Ref 1204 Keith Hills Road
Lillington, NC 27546

The above location has been visited and we have determined that the footing concerns are as follows.

SHEET NAME
 FOUNDATION

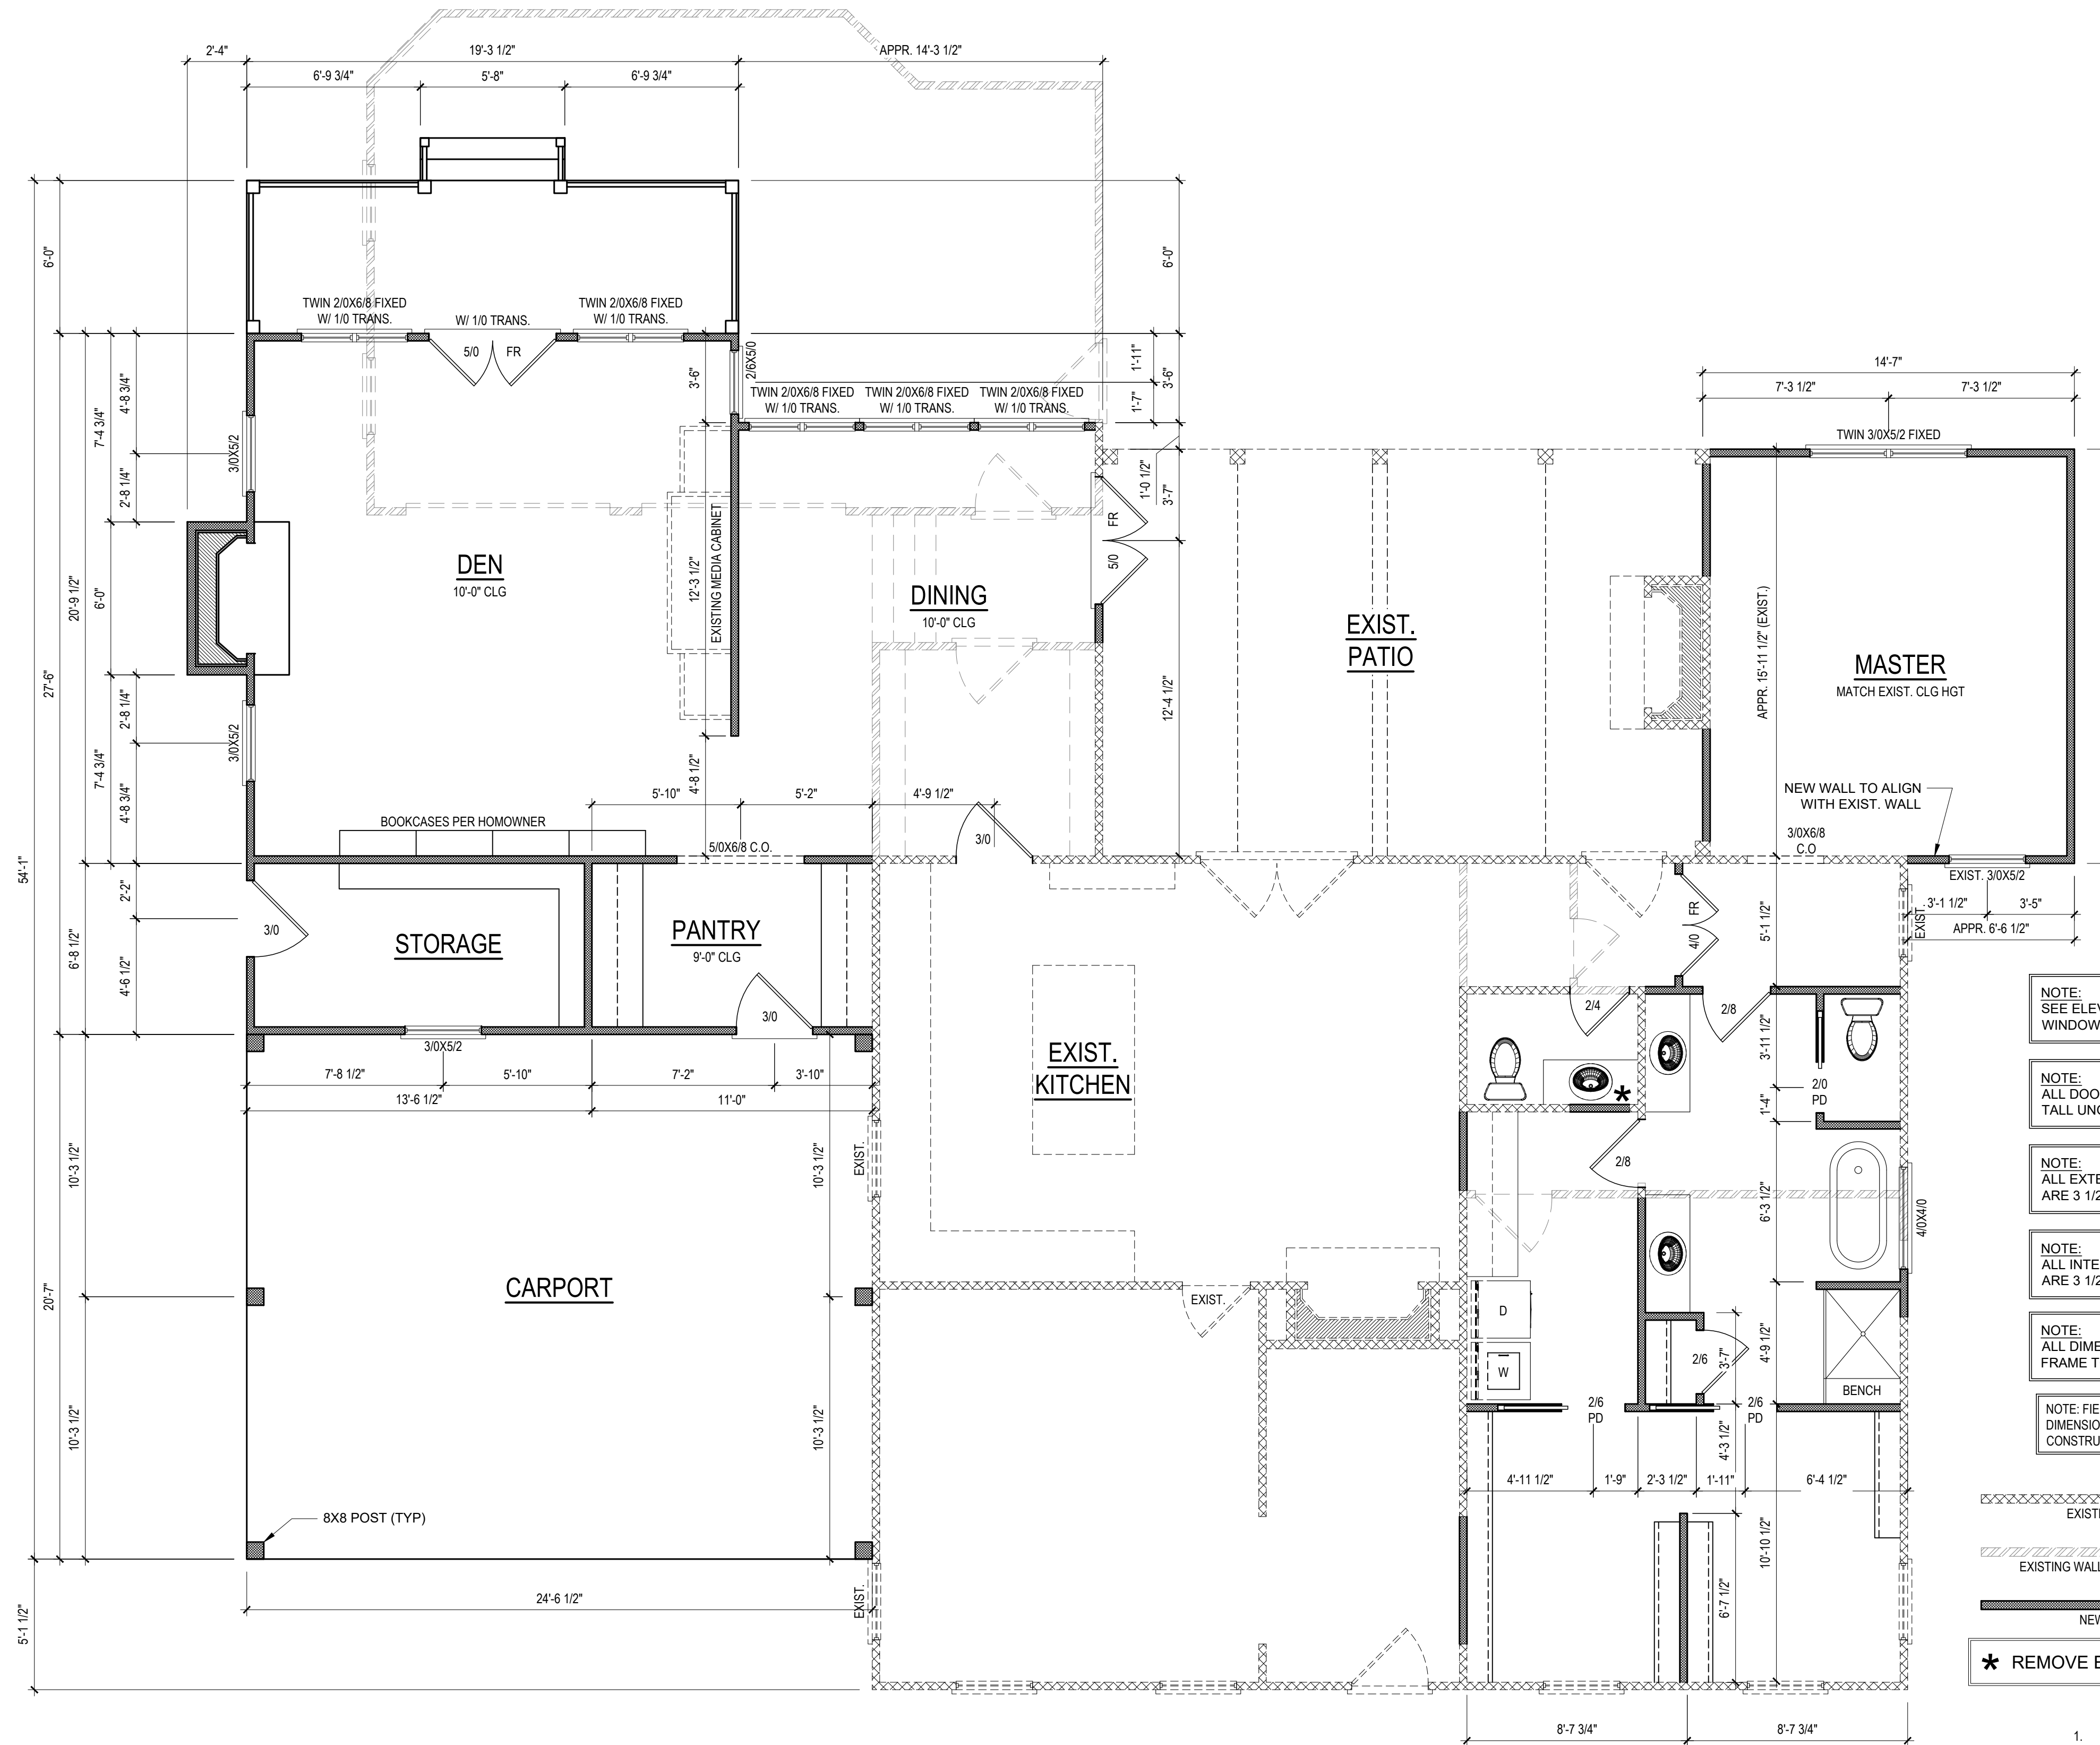
1. The eastern footer has a wet spot that should be dug and drained for approximately 4 feet and reinstall #57 stone for a depth of 4".
2. The pier holding water on the outer edge on the eastern side should be cleaned out and add new #57 stone providing adequate depth of substrate as needed.
3. The outer footer on the west side was checked and found to be adequate as presented.
